HERBATA DATA CENTRE, NAAS - RESPONSE TO REQUEST FOR FURTHER INFORMATION ("RESPONSE TO RFI") FROM KILDARE COUNTY COUNCIL

ADDENDUM TO CHAPTER 4 DESCRIPTION OF THE PROJECT AND
NEED FOR THE PROJECT

NI2615
01
June 2025

Drawing file: 1. Design Drawings / 04. 22217-RKD-ZZ-ZZ-DR-A-1010-OVERALL PROPOSED SITE PLAN.pdf

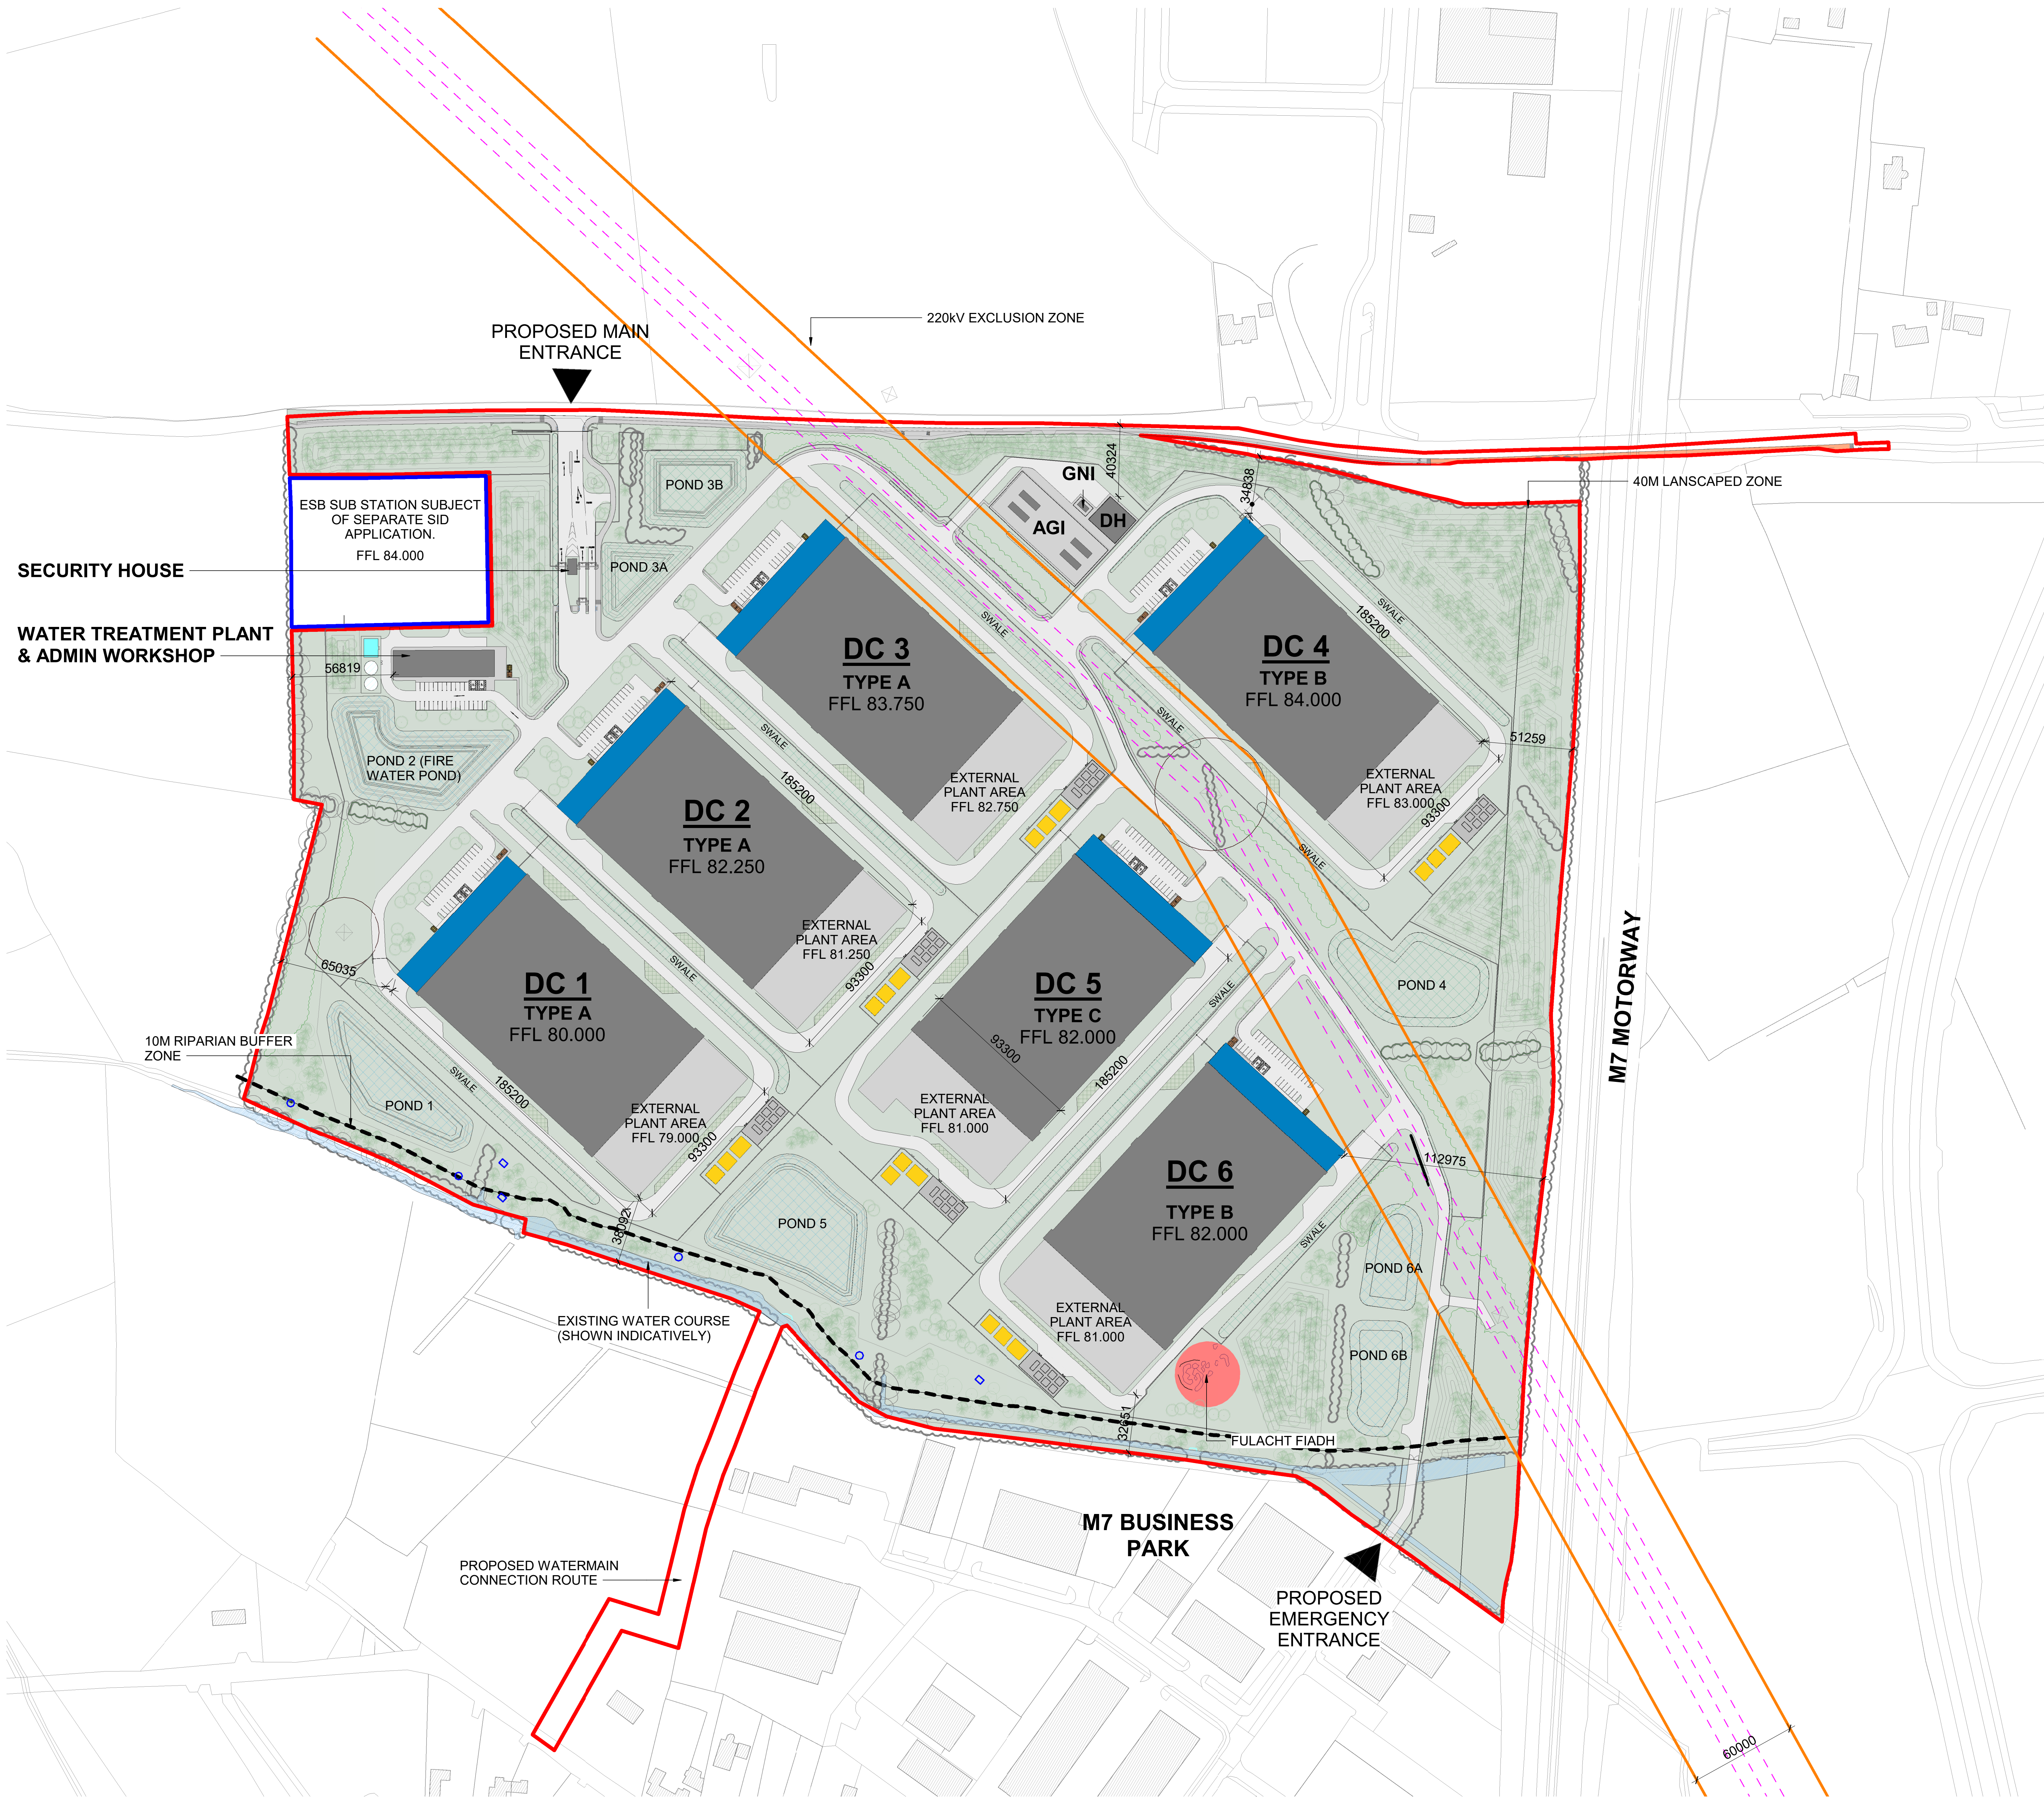
The amended design for Data Centre 4 is primarily in respect of the external plant yard (to the rear of the building) and subsequently, the overall shape of the building and an overall reduction in the area of the building.

In order to accommodate the amended design of Data Centre 4 building, minor amendments to the layout of ancillary elements (such as security fencing, access road, drainage etc) which are within immediate vicinity of the building, are proposed. The component elements of Data Centre 4, the location within the overall site, building height, materials and finishes, remain unchanged.

For the purpose of comparison, Figures 4.1 and 4.2 below, illustrate the previously submitted *Overall Proposed Site Plan* and (amended) proposed site context plan, respectively.
